Lr.No. **A3/5614/90**

Sub: **MMDA - Planning Permission - Construction
of Residential building in Plot No.6 at
S.No.42 of Perungudi Village - Approval
of - Regarding.**

SITE PLAN (SCALE: 1" = 160" (OR) 1 = 200)

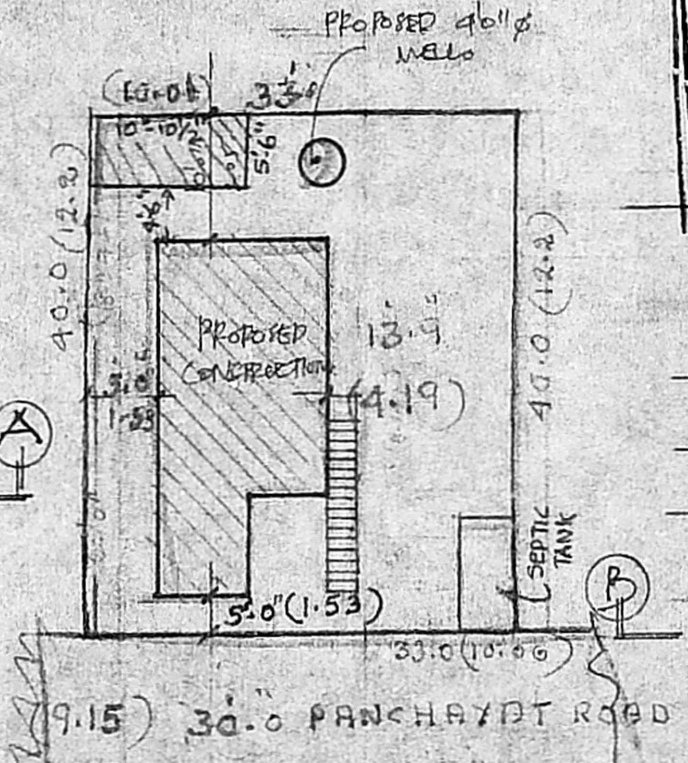
The proposal received in the reference cited for the construction of Residential building at Plot No.6, Survey No.42 of Perungudi Village has been examined and found approvable subject to the condition you are requested to furnish the Revised plan satisfying Side Set Back.
